# CITY OF ALBUQUERQUE

**Re: Garfield Apartments, 501 Girard Blvd SE, Bldg A**  
**Request for Temporary C.O. –Accepted for Bldg A**  
**Engineer's Stamp dated: 2-8-12, (K16/D079)**  
**Certification dated: 6-15-13**

Grading & Drainage
Plan

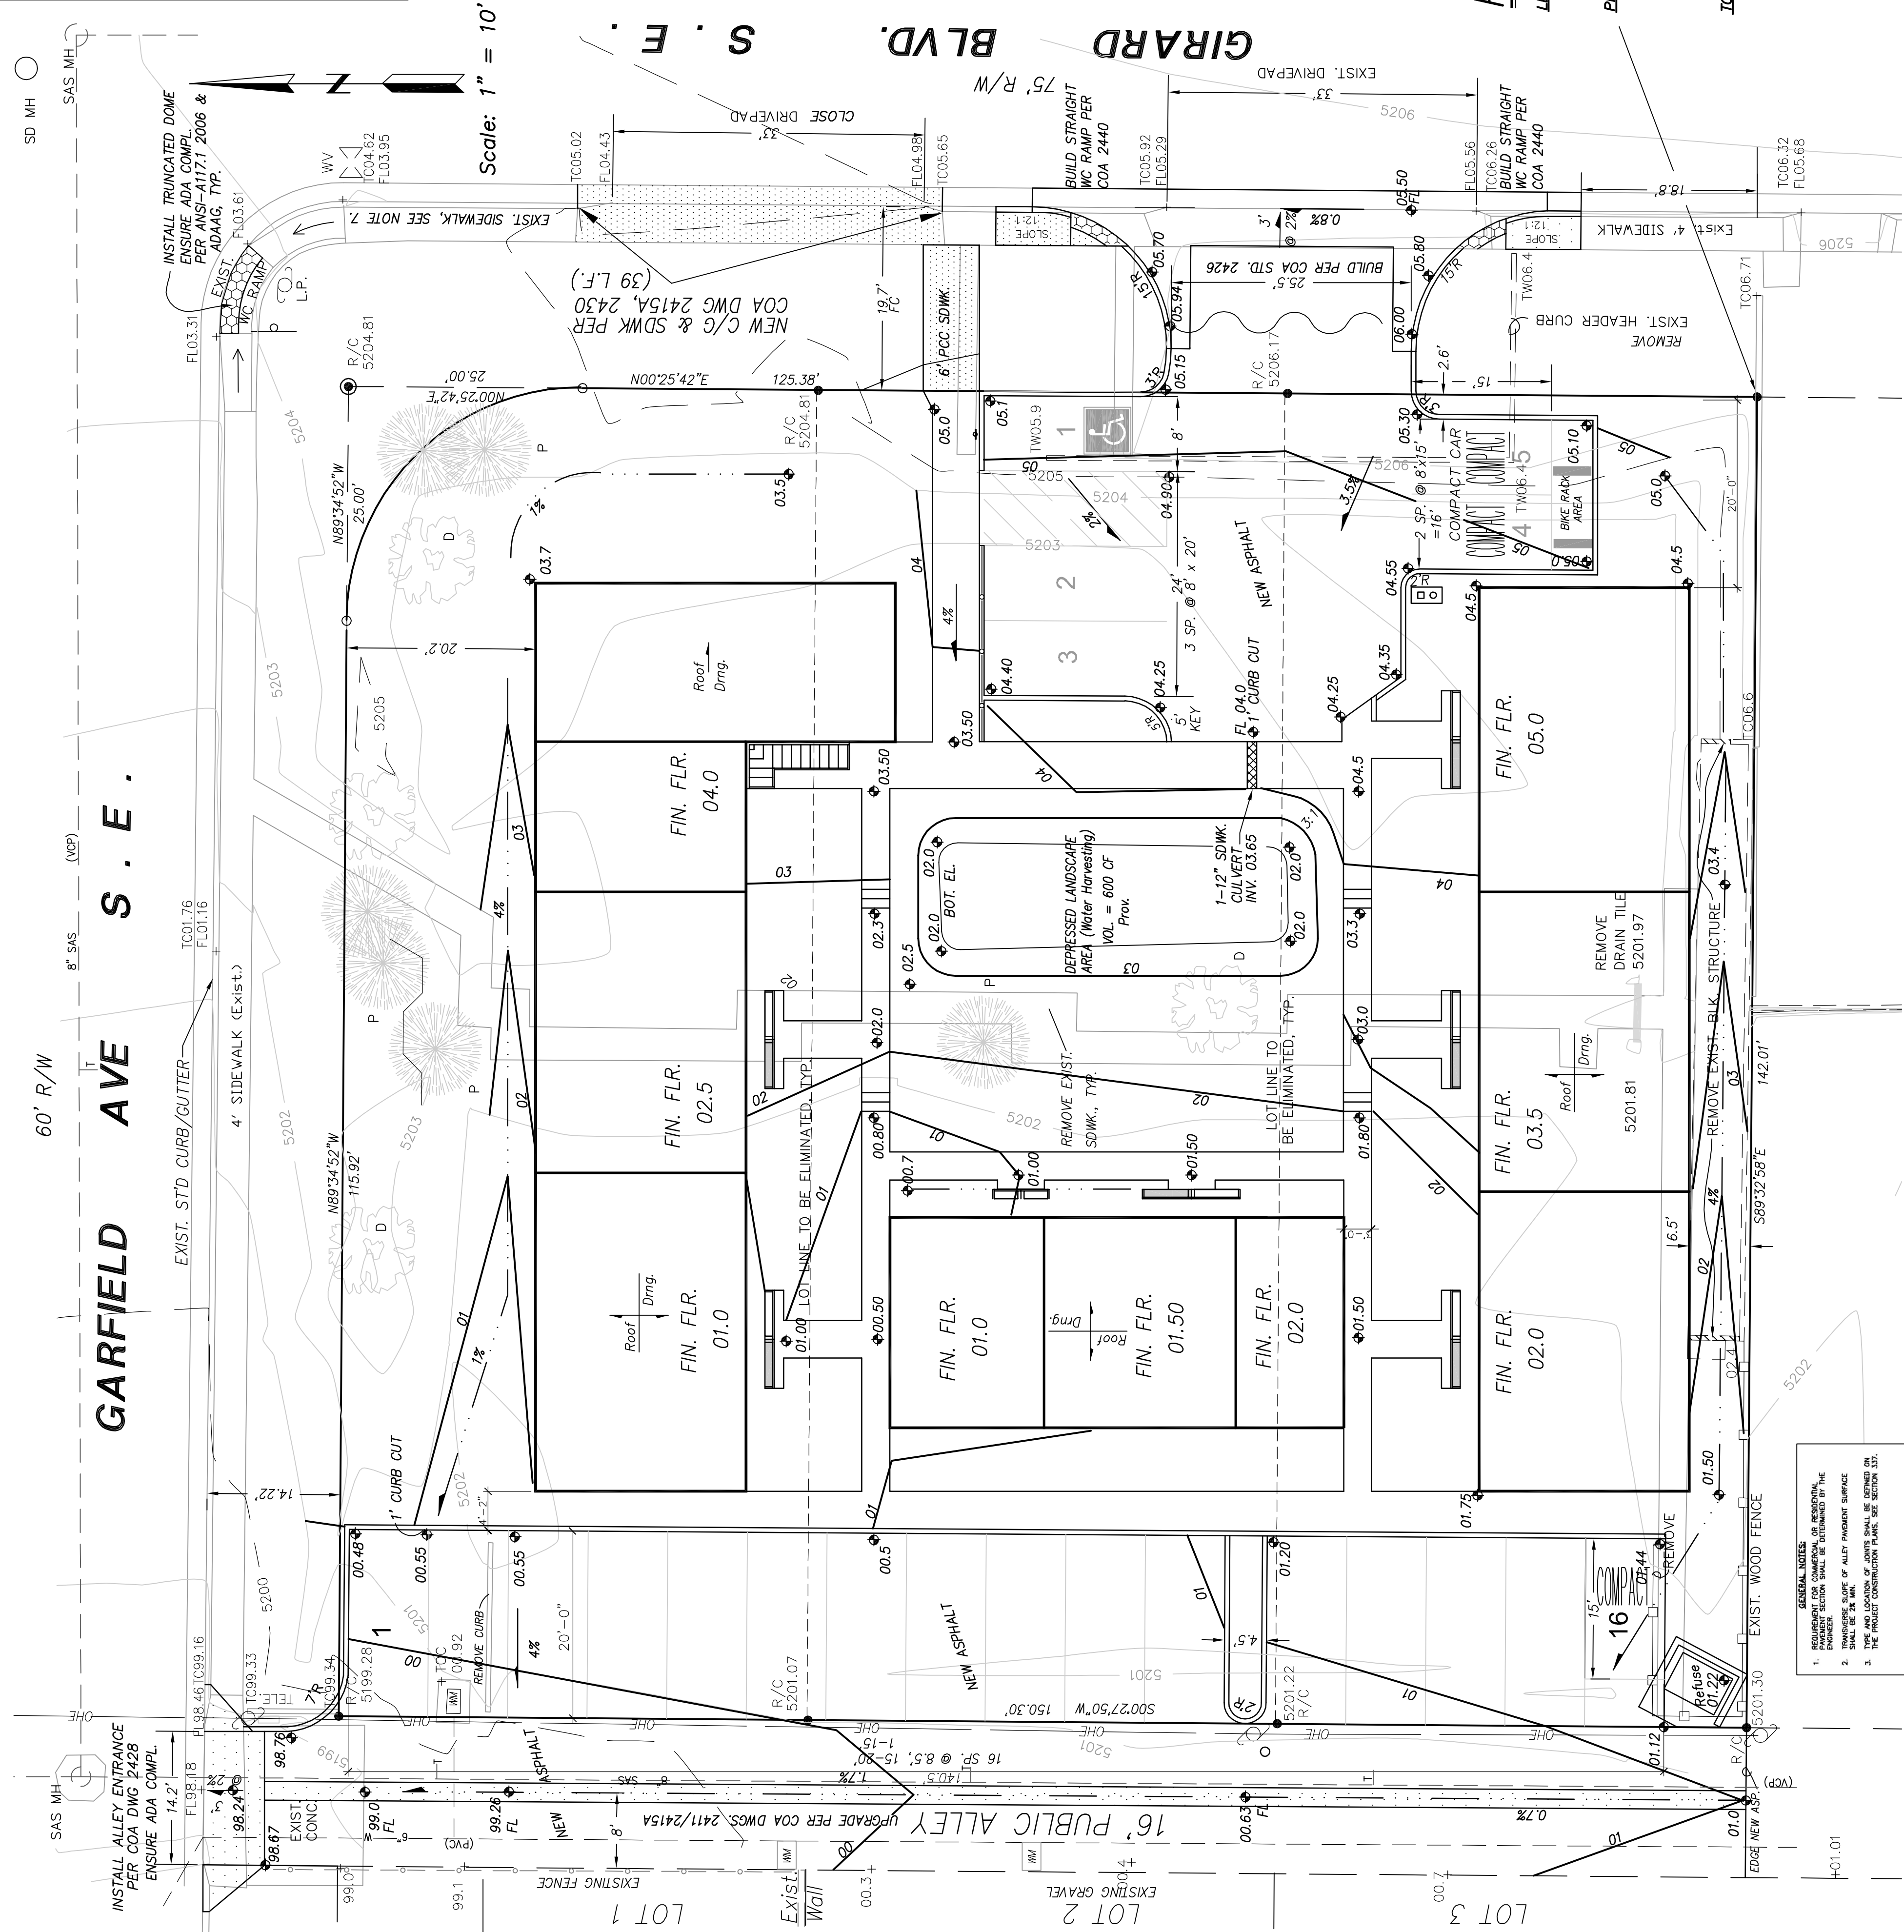
As you know the alley is required to be paved. Since this site drains to the alley, the alley should be constructed prior to requesting future releases of certificates of occupancy.

In addition, when I visited the site on 6-19-13, some items were not built (sidewalks, side-yard swale) as indicated on your certification and some items were built (2 foot high planter, step in sidewalk) that were not on the approved plan and not indicated on the certification. Please show accurate site conditions on future certifications.
